**Subject:** RE: Attached letter from Kirklees Council regarding application number 2024/91388 at location Cummins Turbo Technology, St Andrew's Road, Huddersfield, HD1 6RA

Bridges & Structures Manager  
Structures Section  
Highways and Streetscene  
Kirklees Council

**FOOTBRIDGE LEVEL - AS PROPOSED**  
1 : 200

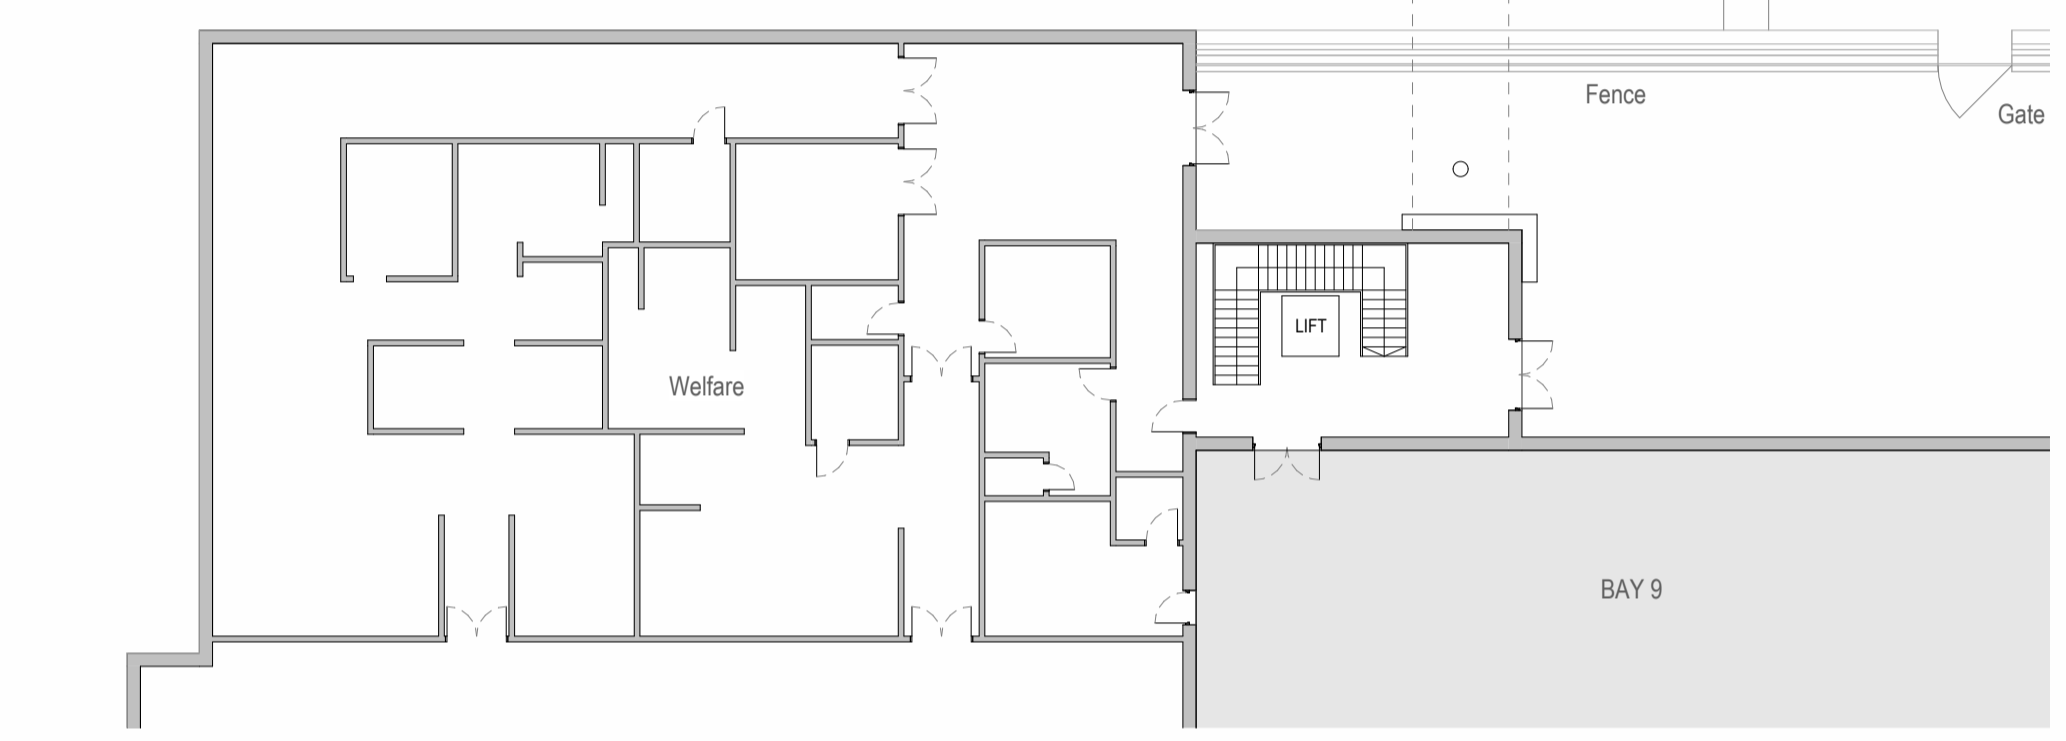
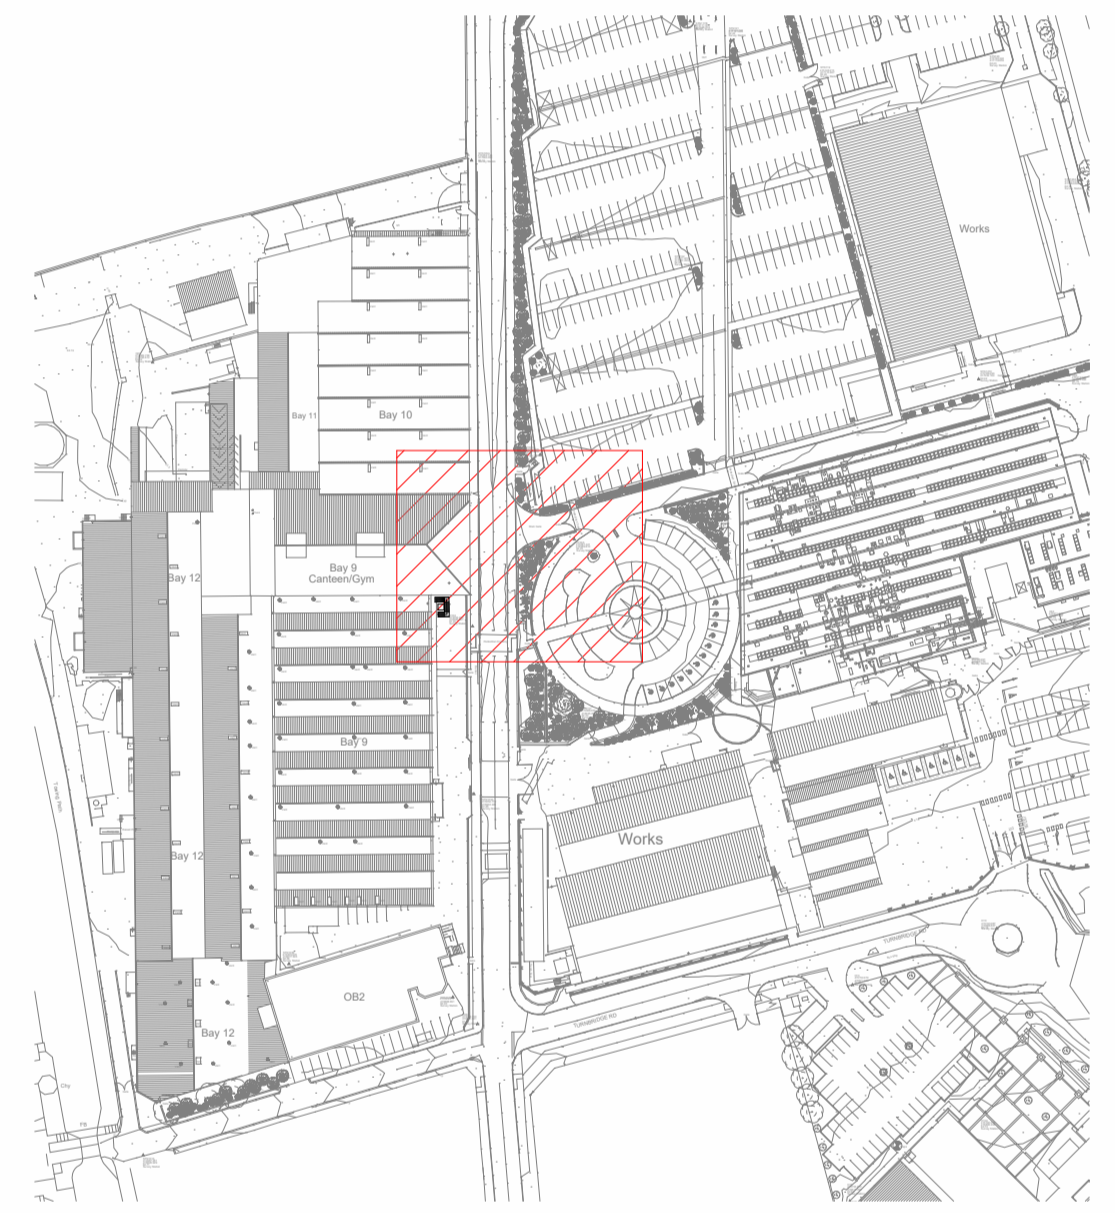
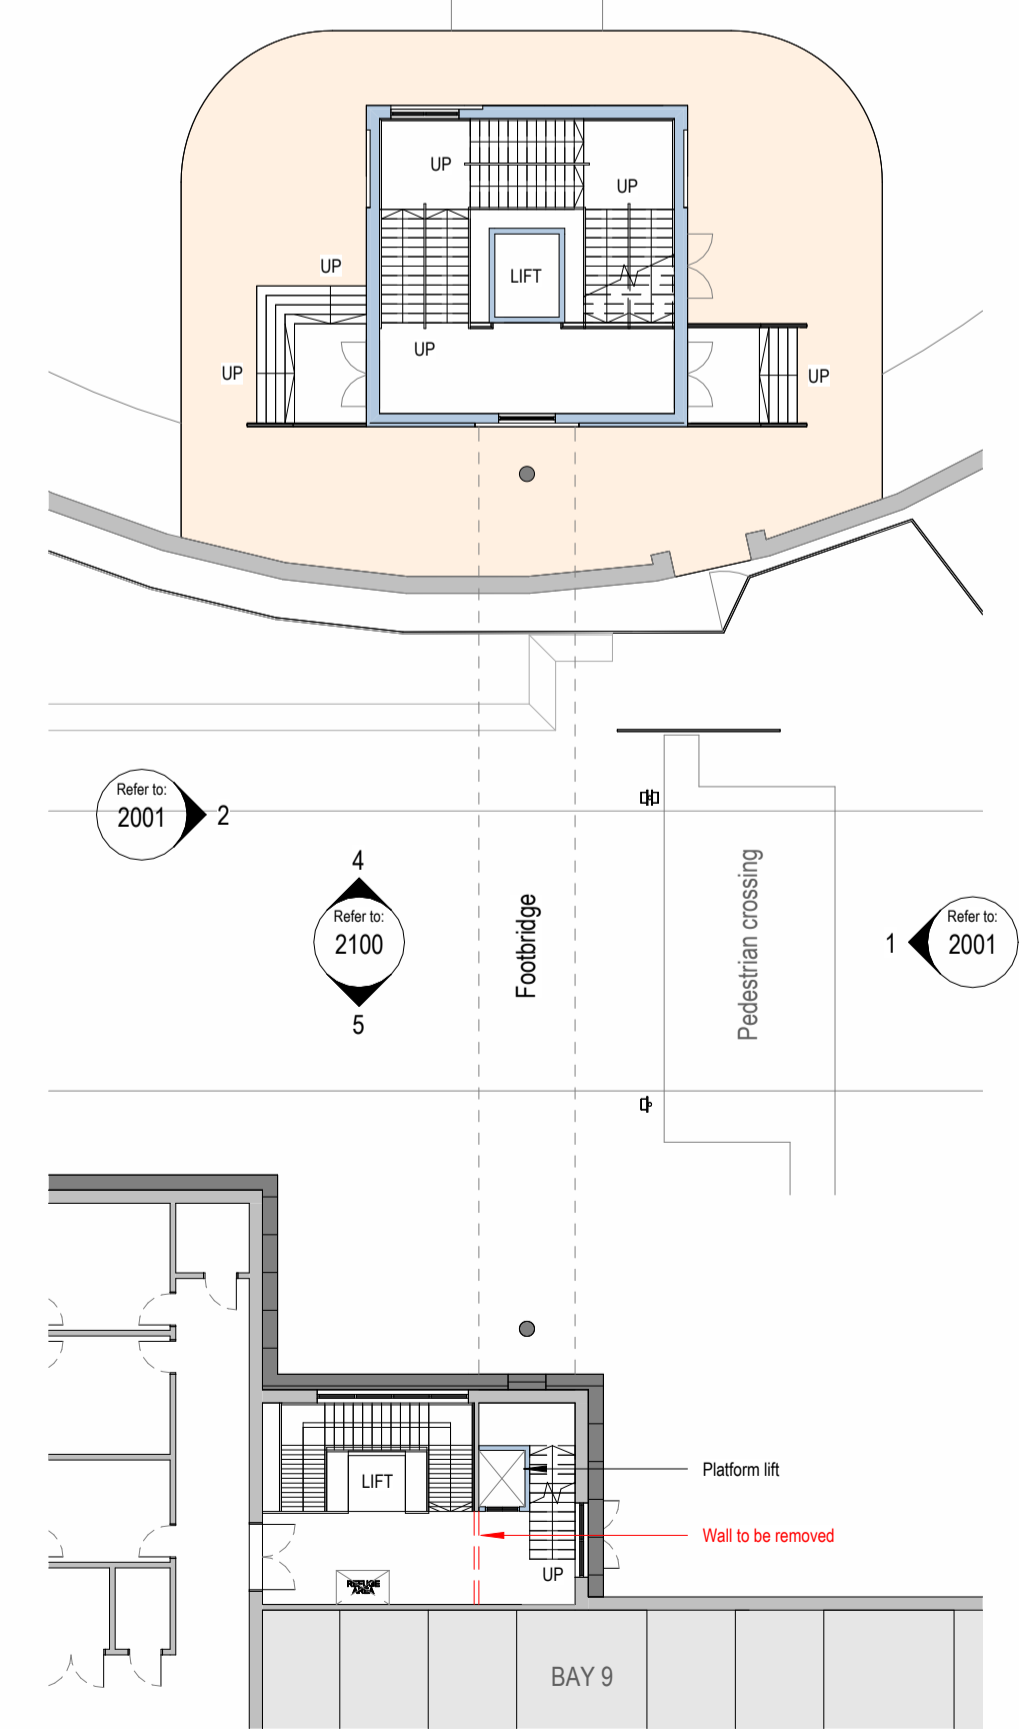
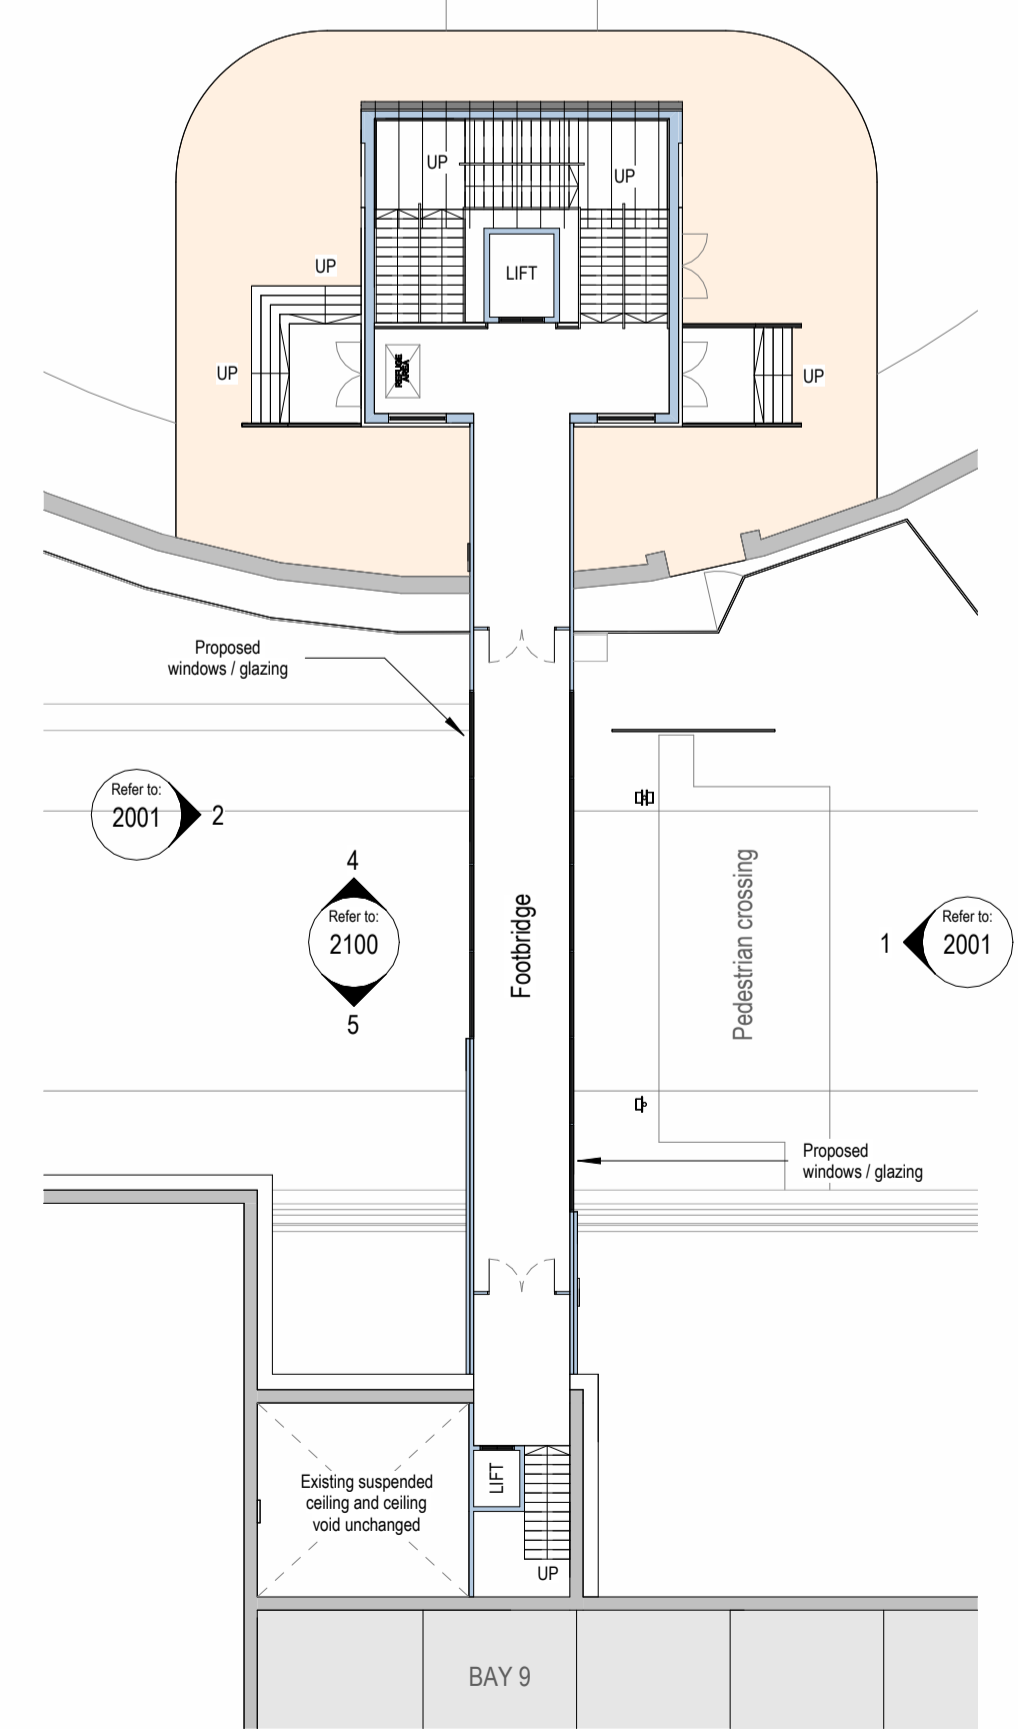
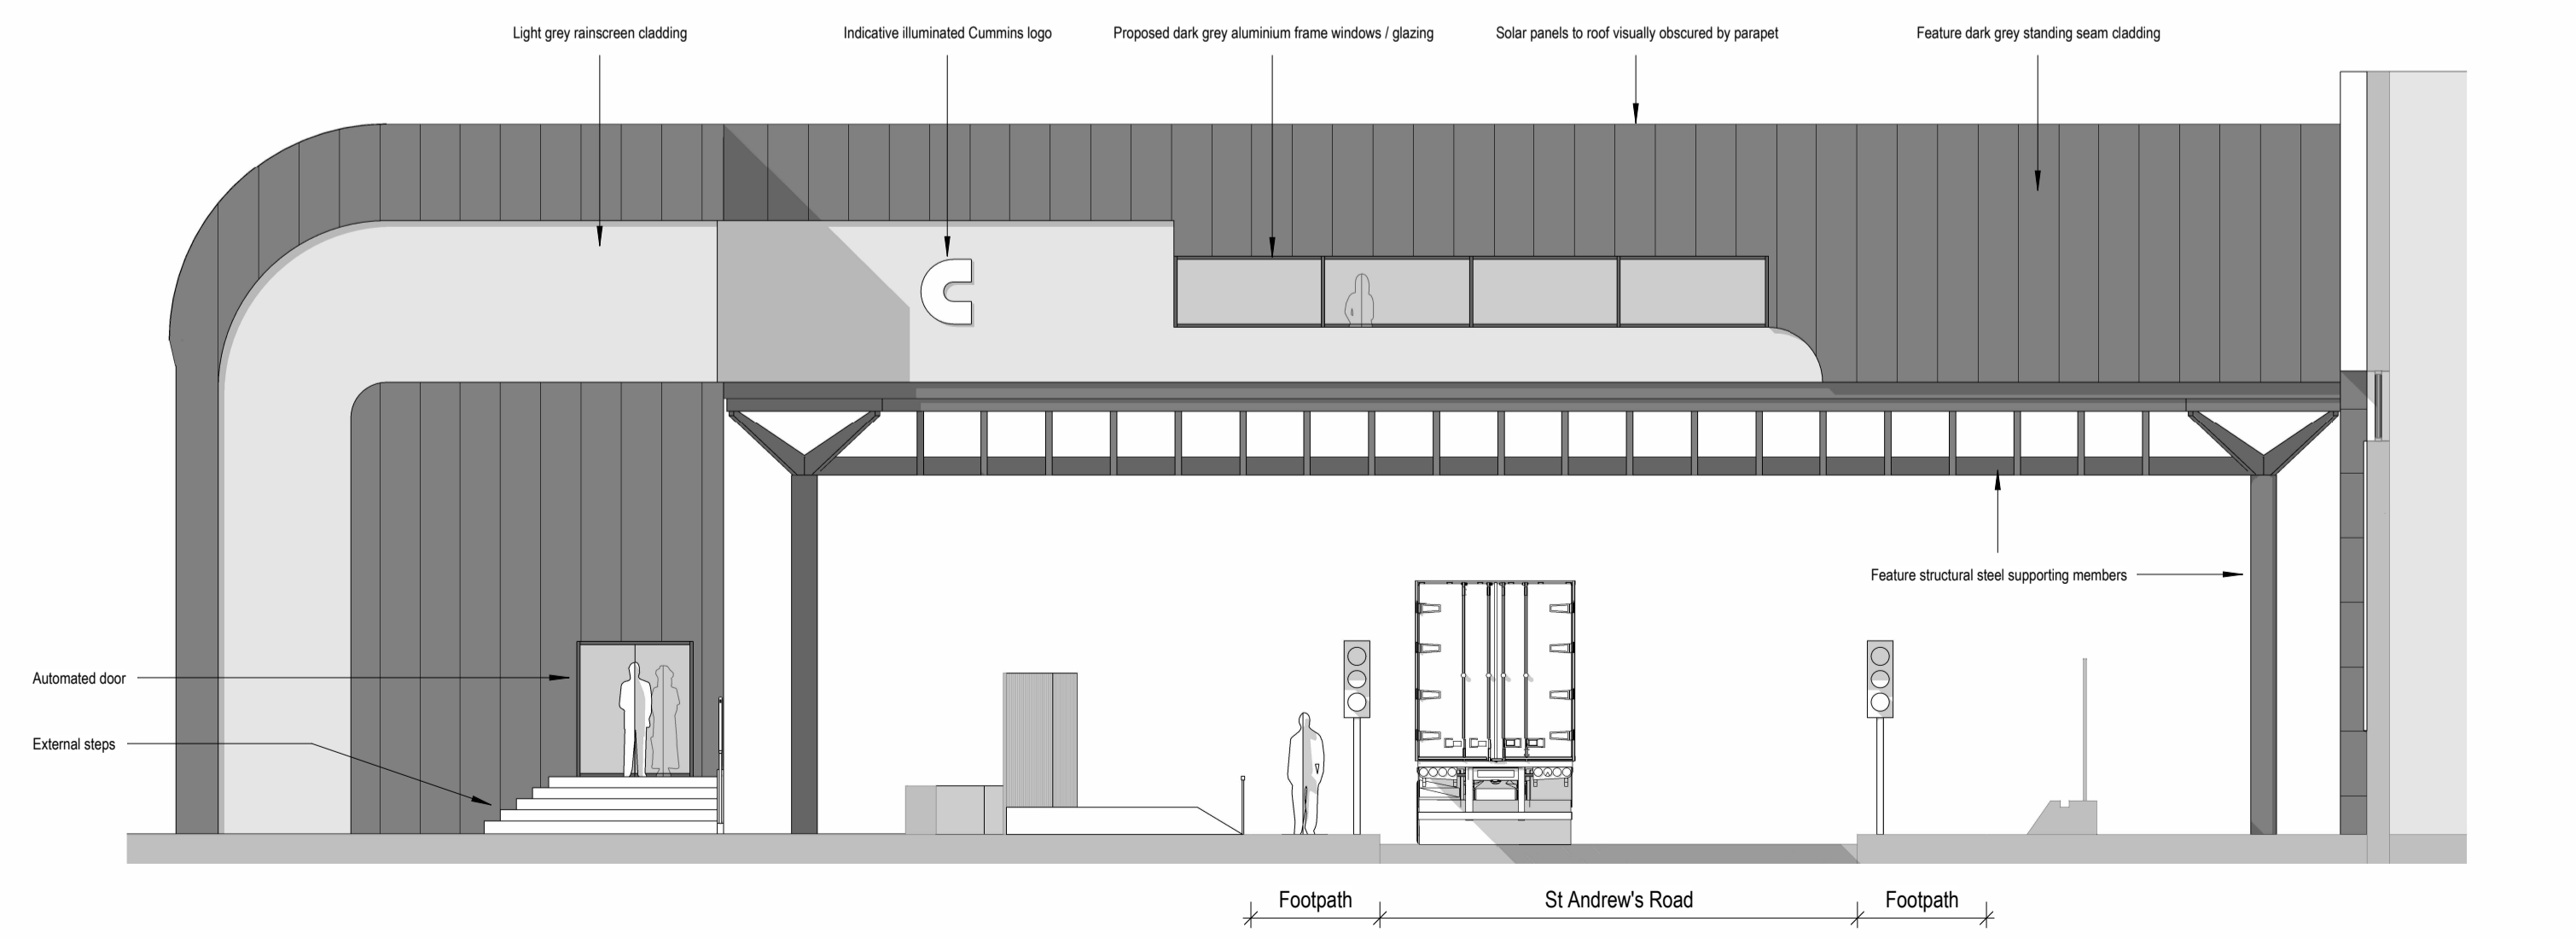
Please arrange for the inclusion of the following condition:

- 1) Before the development commences, the design of proposed footbridge over the existing highway shall be submitted (via submission of an AIP) and approved by the Highway Authority in writing. The approved scheme shall be implemented prior to the commencement of the proposed development and thereafter retained during the life of the development.
